# Gatwick Airport Northern Runway Project

Statement of Common Ground Between Gatwick Airport Limited and Tandridge District Council

DATE: MARCH 2024

Application Document Ref: 10.1.9

Diagram 3.3.9: Model performance before and after adjustment, London zone

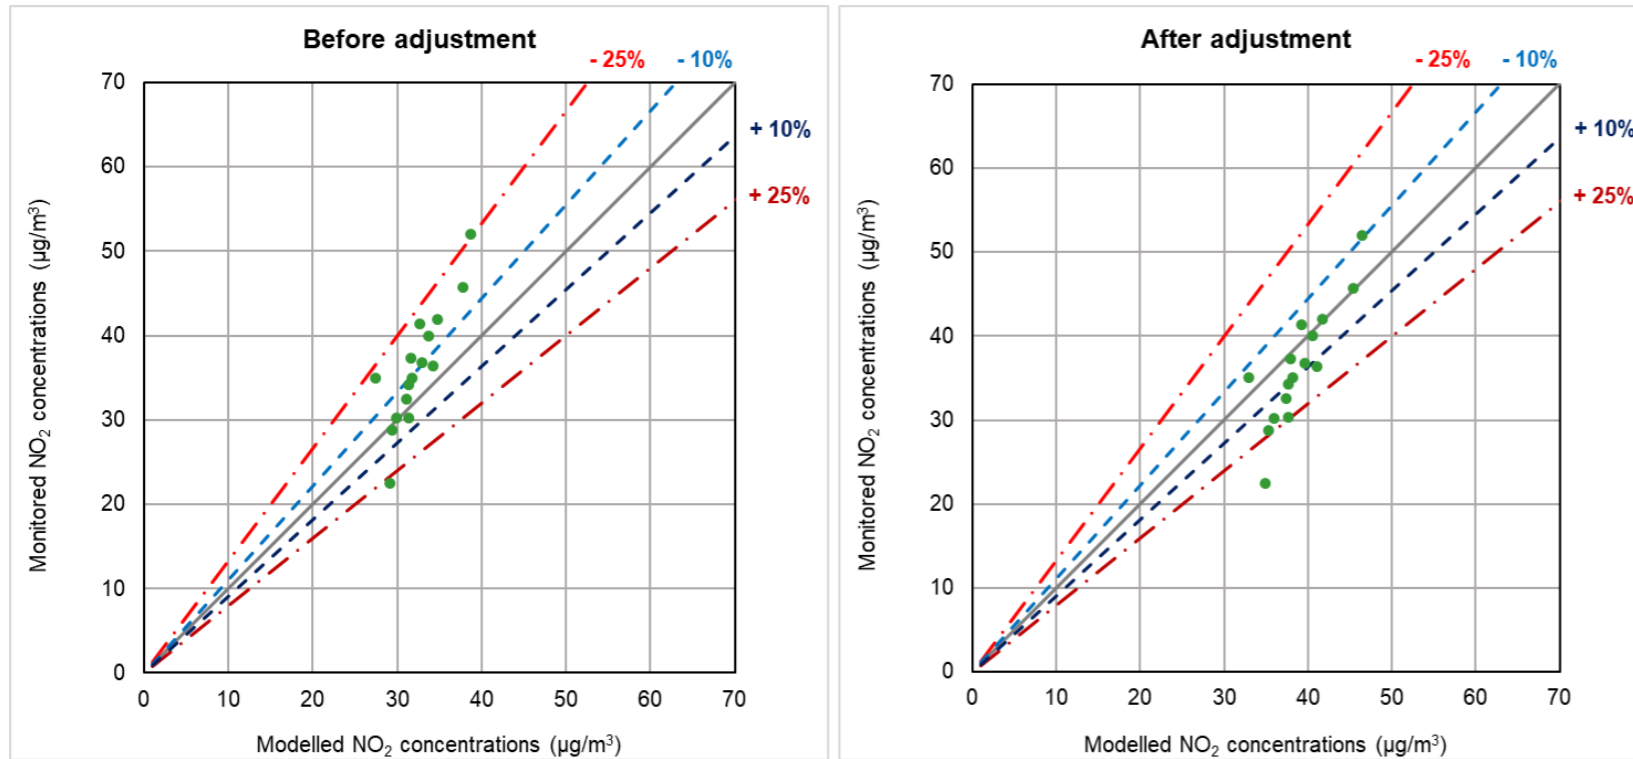
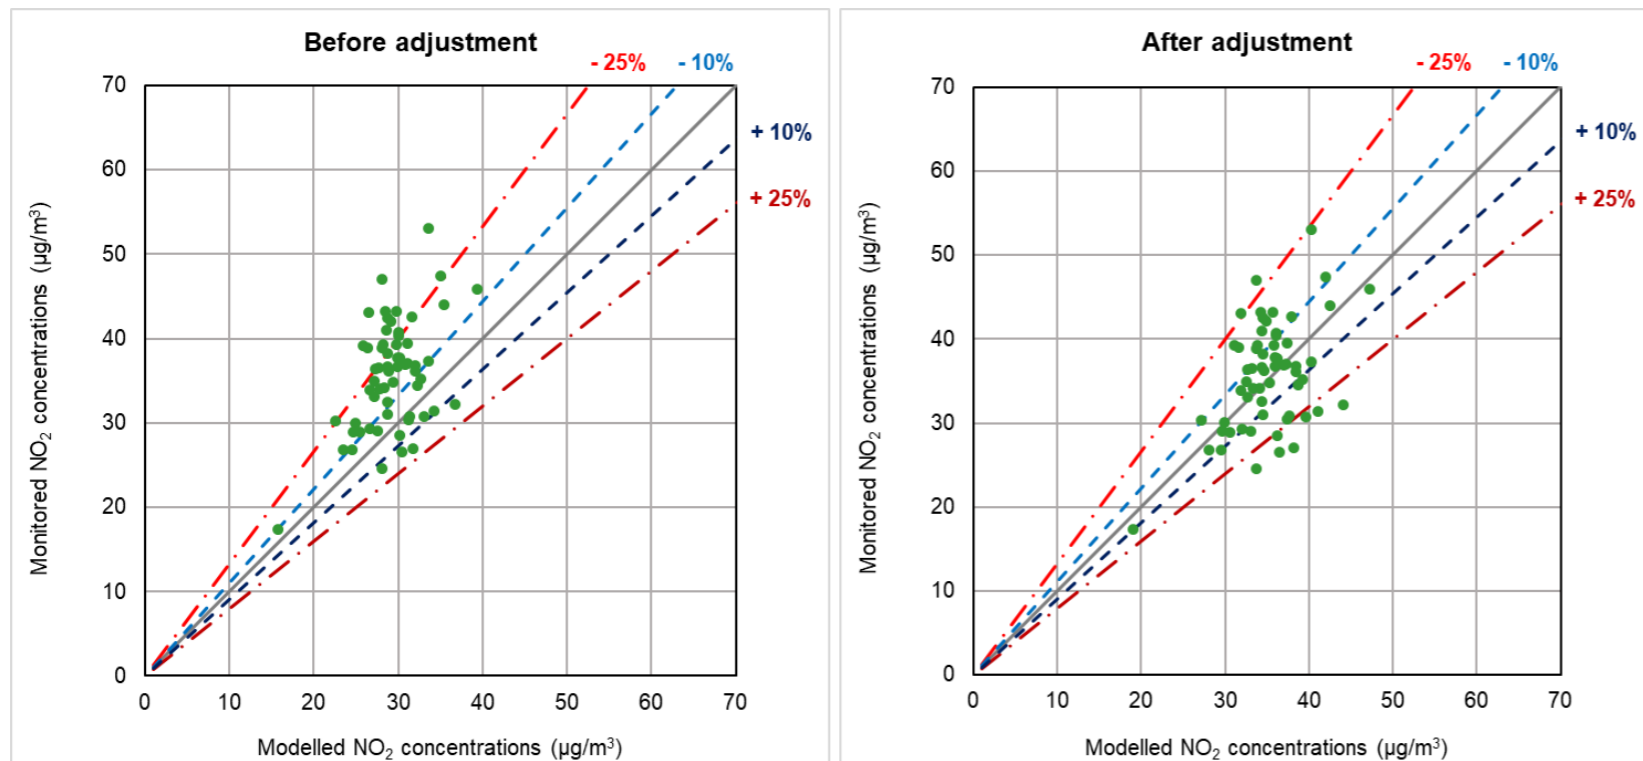
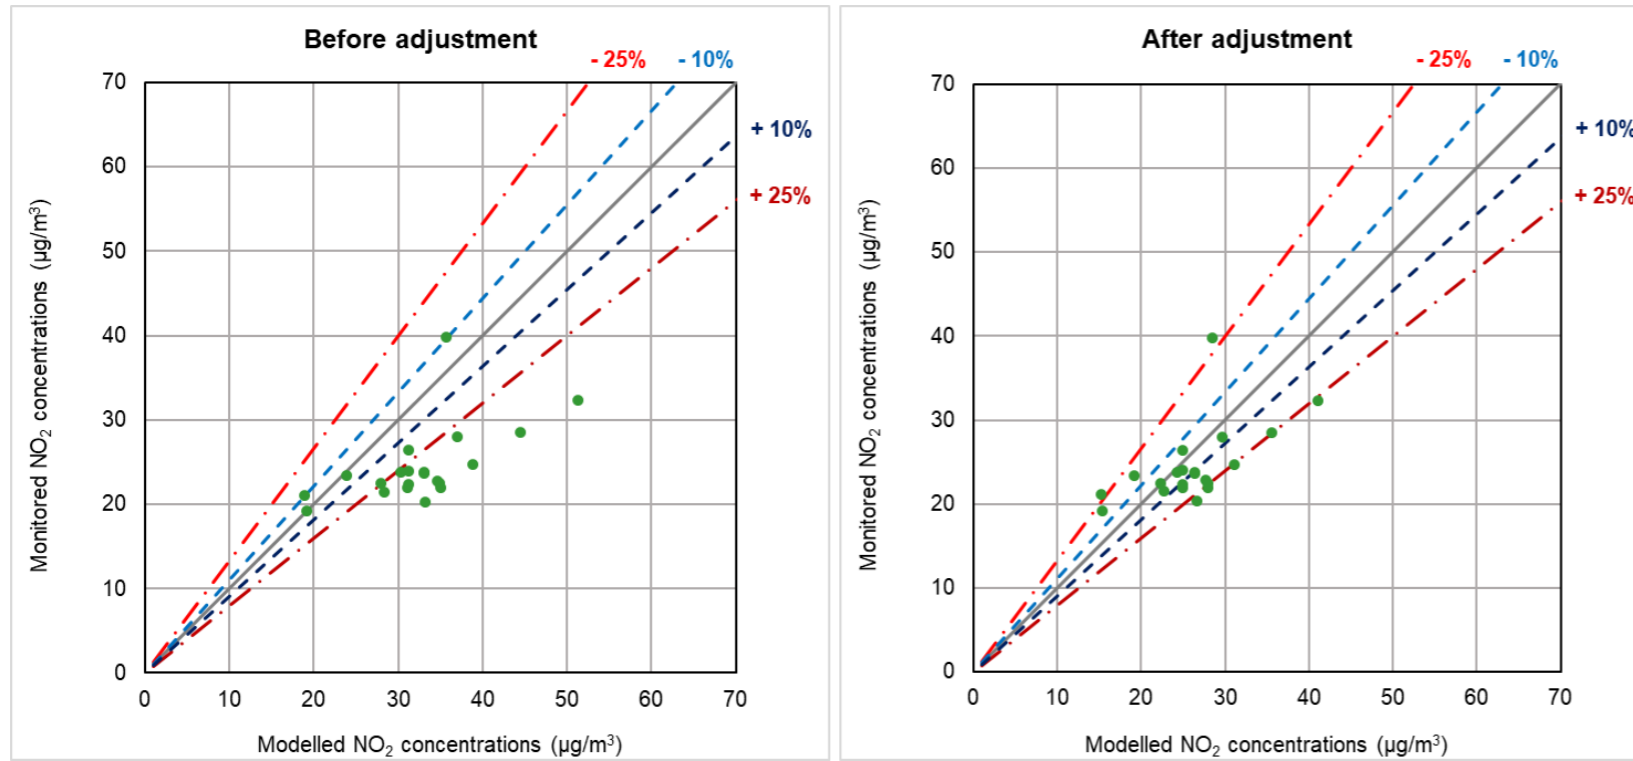
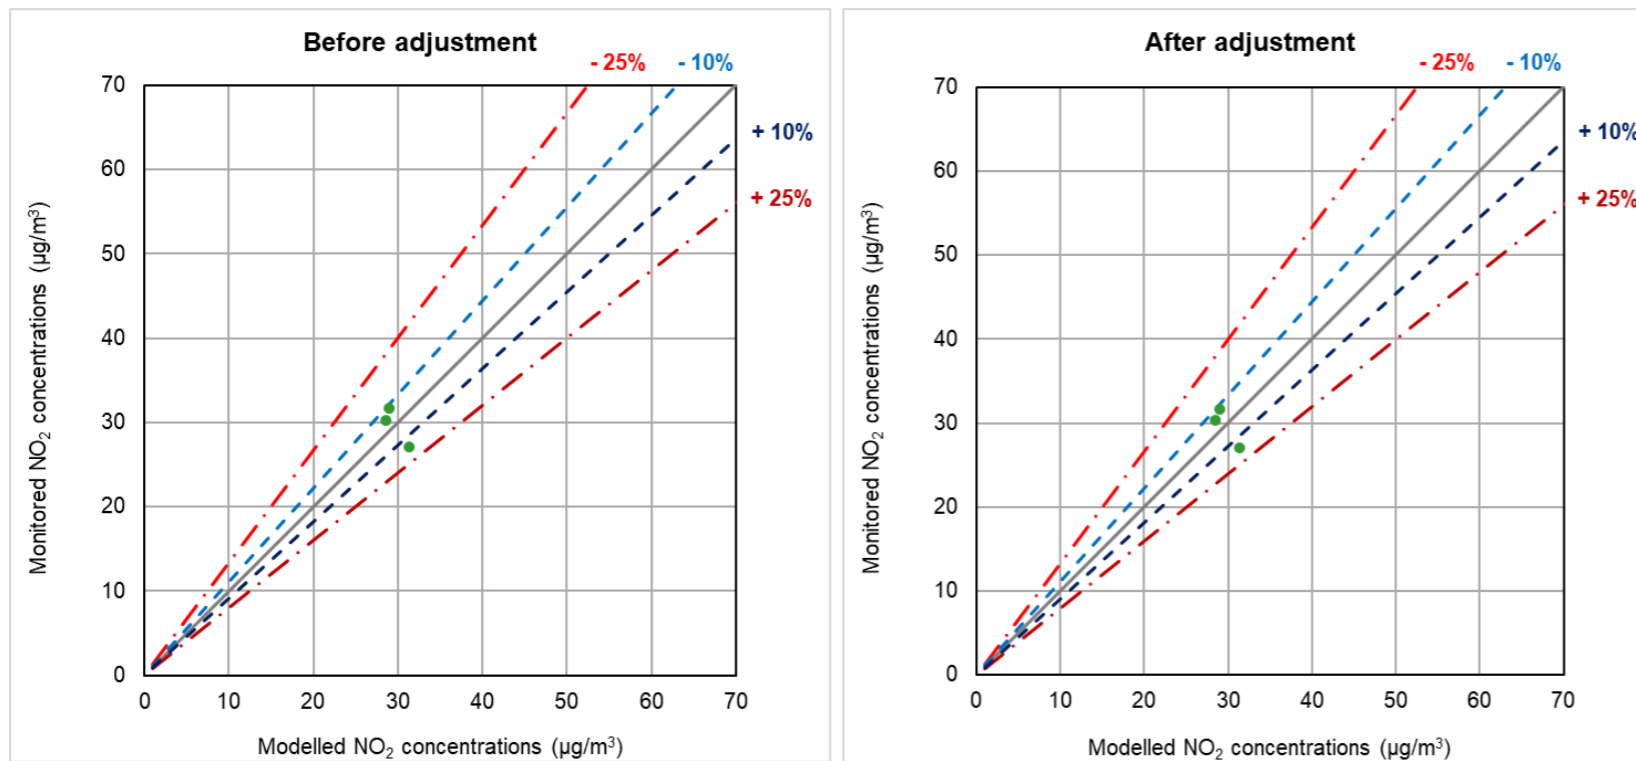
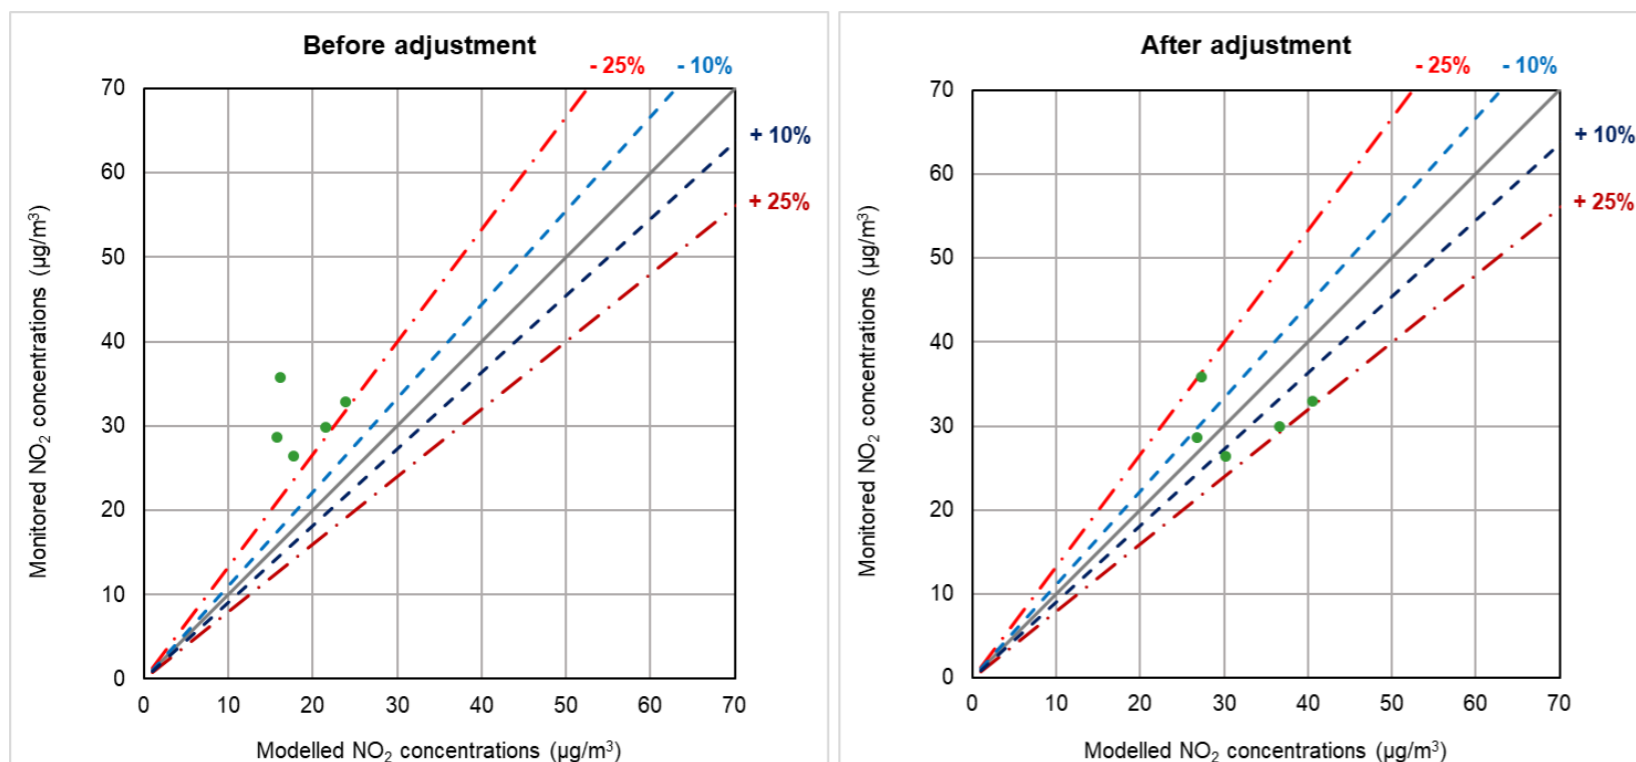
2.2.2.5	Verification zones	<p>TDC disagrees that enough justification was provided for the selection of different verification zones and why the model would be expected to perform differently in each area. A sensitivity test is required to demonstrate that the conclusions of the assessment would not change if a single verification factor were used.</p> <p><b>Updated position (Deadline 1):</b> Further discussion is required on this point and the request for a sensitivity test examining the use of a single verification factor still remains.</p>	<p>Full details of the model verification process are included in Section 3 within the ES Appendix 13.6.1. Table 3.3.1 provides details on the verification zones used.</p> <p>The verification methodology was agreed with local councils at the modelling methodology workshop in November 2022. Model files and results were provided to the TWG via email 18<sup>th</sup> August 2023.</p> <p>The process followed during the ES took into account feedback from the local authorities at the PEIR stage and following discussions on the agreed approach.</p>	<p><b>ES Appendix 13.6.1 Air quality Data and Model Verification</b> <a href="#">[APP-159]</a>,</p>	Under discussion
